18/98 Chandos Street
ASHFIELD NSW 2131

SUBMISSION – EIS –WESTCONNEX M4 EIS (SSI 6307)

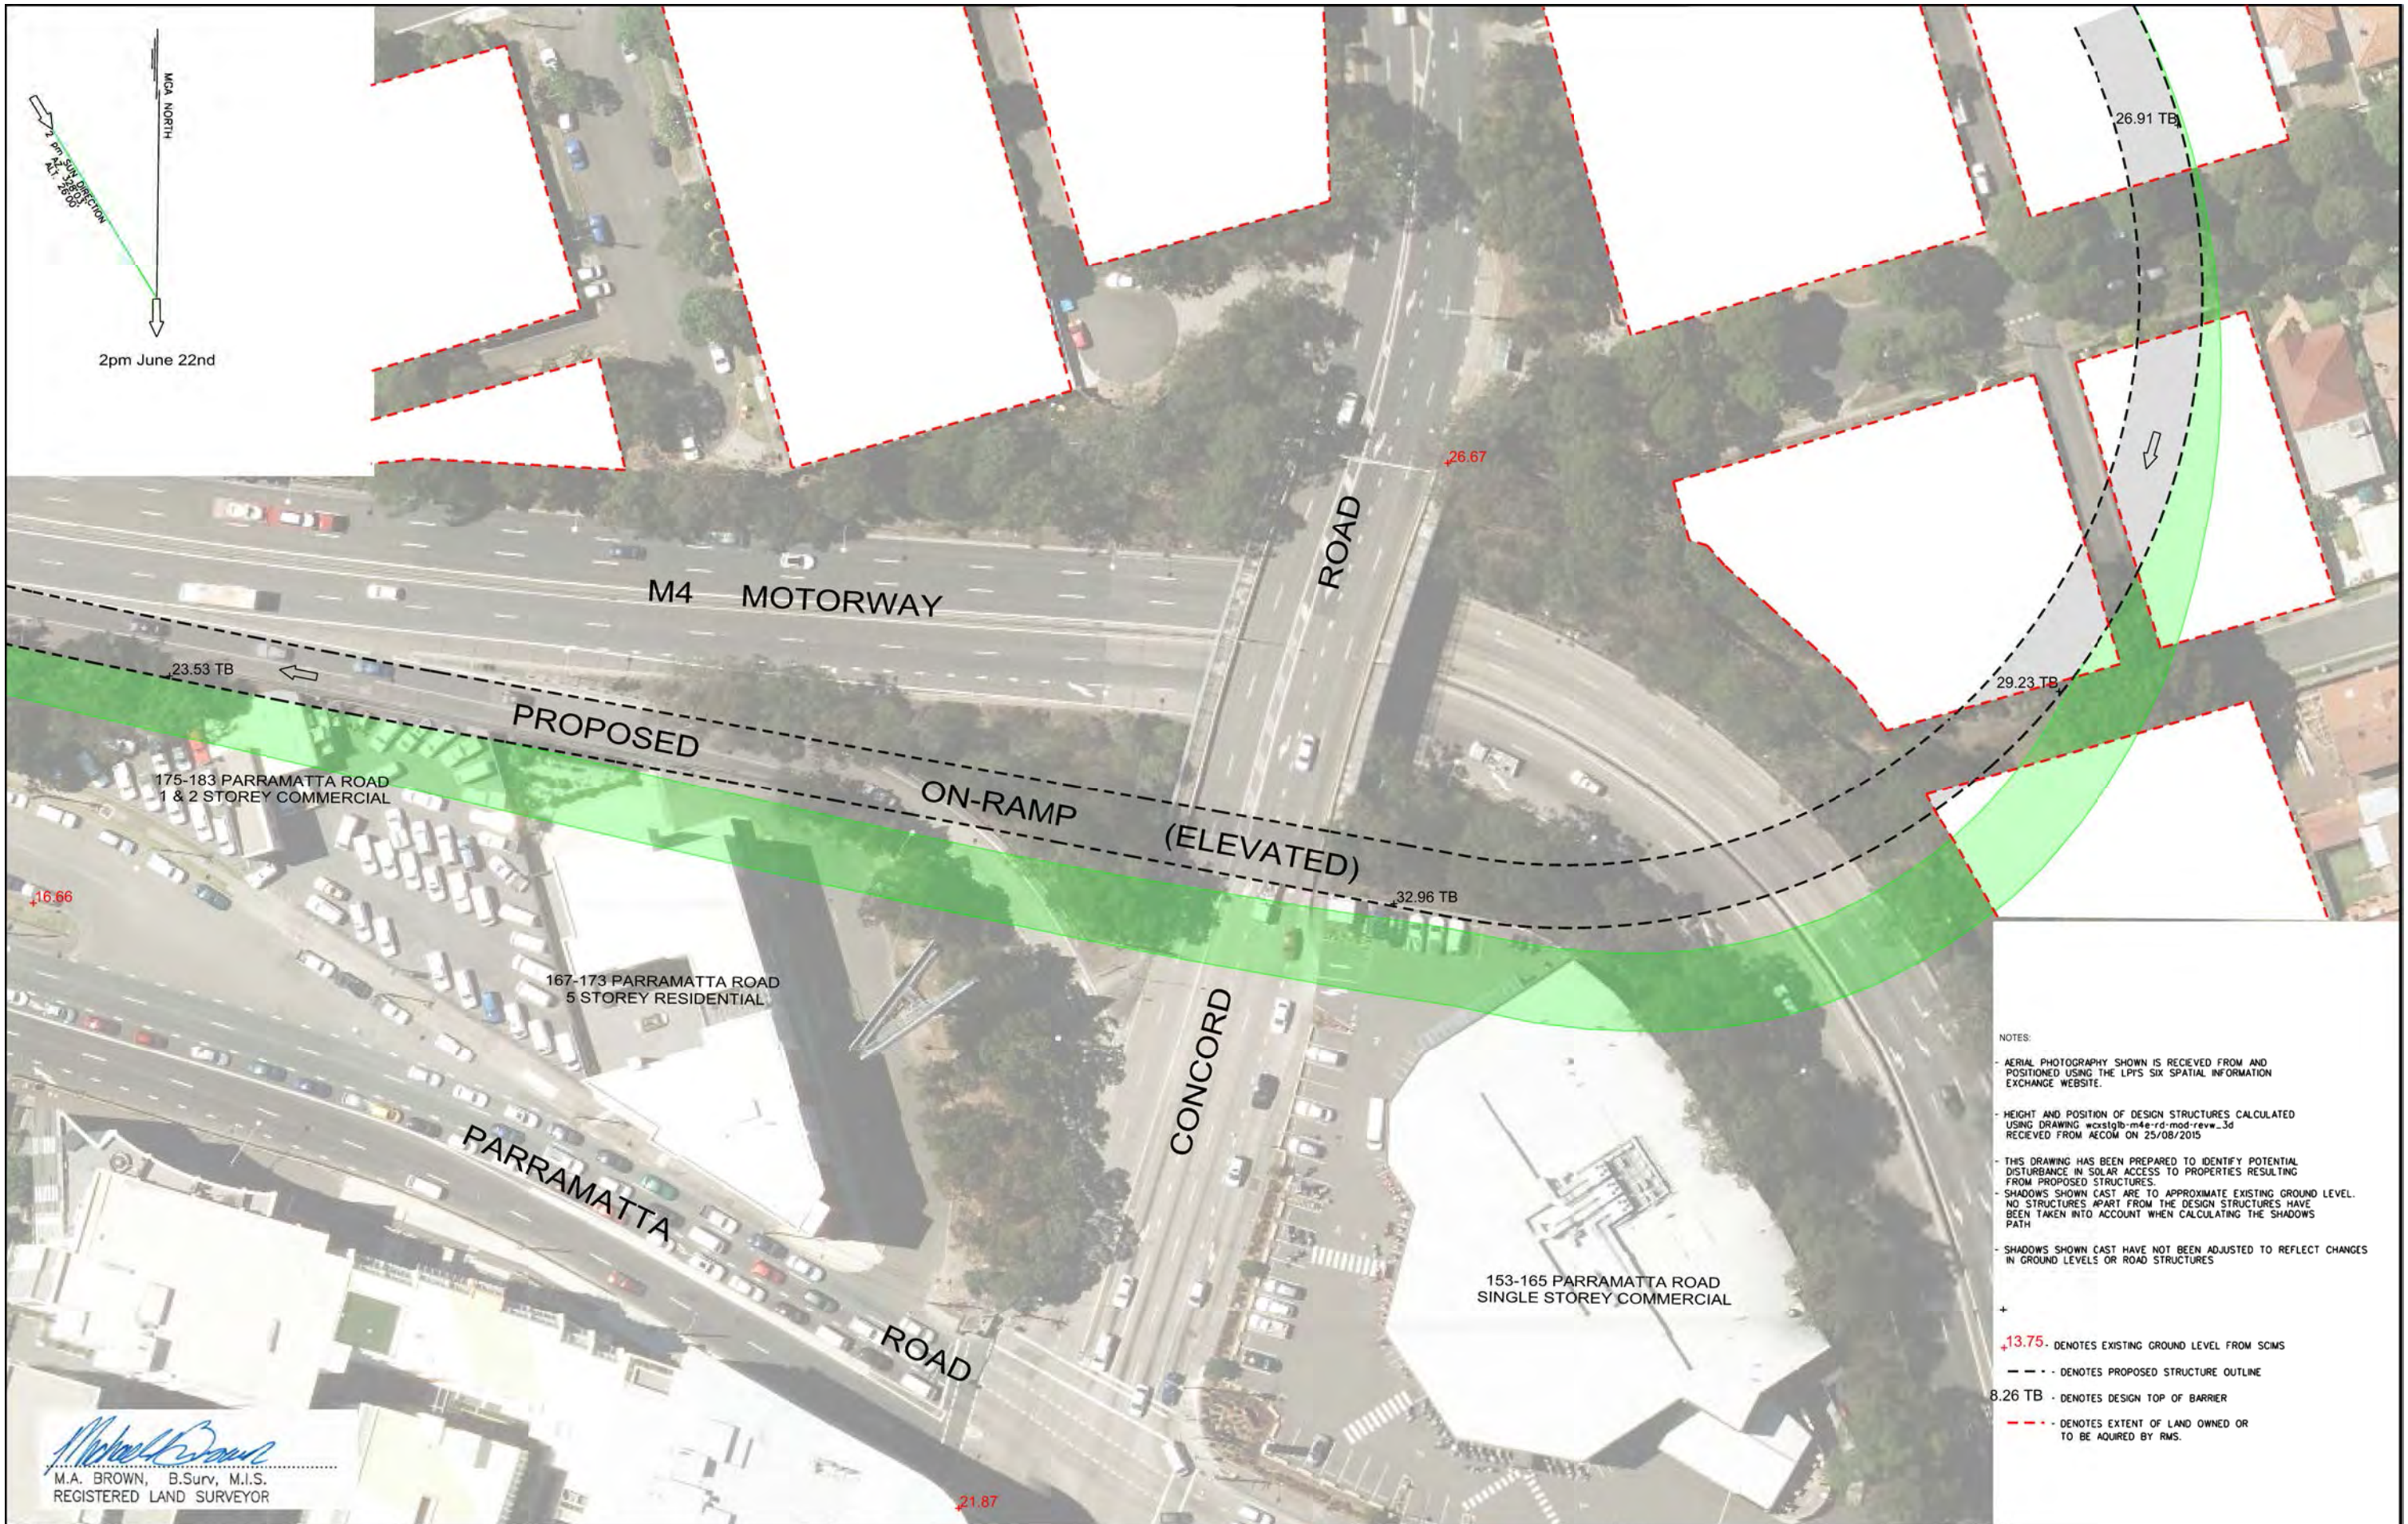
The realignment of Parramatta Road to facilitate the tunnel portals at the Parramatta Road Interchange will result in a significant increase in noise at numerous residences between Orpington Road and Bland Street, and particularly at 98 Chandos Street (SP66454), which contains fifty-six residential lots. The realignment of Parramatta Road will result in the distance between the nearest point of the roadway and the apartment building at 98 Chandos Street being reduced from approximately 40 metres to approximately 6 metres. As noted in the EIS, the effect of the reduction in distance to Parramatta Road will be compounded by the demolition of existing noise screening provided by adjacent buildings that are to be acquired and demolished to facilitate the interchange.

The EIS indicates that external noise levels are expected to be greater than 10 dBA above the NCG target at 98 Chandos Street. EIS Vol. 2C App I Section 7.5 indicates that where the NCG internal criteria in habitable rooms can only be achieved with windows and vents closed, then mechanical ventilation should be provided (subject to individual consultation with dwelling owners) to ensure sufficient airflow inside the dwelling, so as to meet the requirements of the Building Code of Australia. Given the existing building construction at 98 Chandos Street, in which most of the bedrooms and living rooms have little ceiling void space in which to install mechanical ductwork, it is unclear how this can be practicably achieved. It will be very difficult and disruptive, if not impossible, to meet the NCG target at 98 Chandos Street without the provision of a noise wall.

The EIS identifies twenty-one (21) buildings, between Orpington Street and Bland Street, as receivers that should be considered for additional noise mitigation. Sixteen (16) of these buildings trigger both of the cumulative limit and the noise increase criteria identified in the EIS. Many of the said buildings, including 77-79 and 98 Chandos Street and 1, 1A, 3-5, 7-9, 11, 13, 15 and 17 Loftus Street are high density residential constructions. A large number of residents would benefit from a noise wall, which would provide significant attenuation of noise for at least the first two floors. A noise wall should be constructed along the westbound side of Parramatta Road, running from Orpington Street to Bland Street. At the Chandos Street intersection, a noise wall should be provided on the east side of the street in order to provide noise mitigation for 77-79 Chandos Street and should be provided along the southern side of part of the proposed driveway at 98 Chandos Street in order to provide noise mitigation for 90 Chandos Street.

The noise wall should consist of clear acrylic or similar panels where a non-translucent wall would result in unacceptable overshadowing of properties. The noise wall should be similar to the 455m long wall that was constructed along the north side of Syd Einfeld Drive, Woollahra, in 2013-2014, which consists of combination of reinforced concrete and acrylic panels. The noise mitigation that I am proposing is not more onerous than that which was constructed along Syd Einfeld Drive and, due to the large number of residents that would otherwise be affected by noise, the benefit would be great.

1. A noise wall should be constructed along the westbound side of Parramatta Road, running from Orpington Street to Bland Street. At the Chandos Street intersection, a noise wall should be provided on the east side of the street in order to provide noise mitigation for 77-79 Chandos Street and should be provided along the southern side of part of the proposed driveway at 98 Chandos Street in order to provide noise mitigation for 90 Chandos Street.
2. The criteria for the provision of architectural noise mitigation should be the same for all residences and all floors. The EIS is deficient in that it has completely excluded the floors above the second floor in its modelling and recommendations, except to state that RMS has a policy of completely excluding even the consideration of noise mitigation above the second floor.
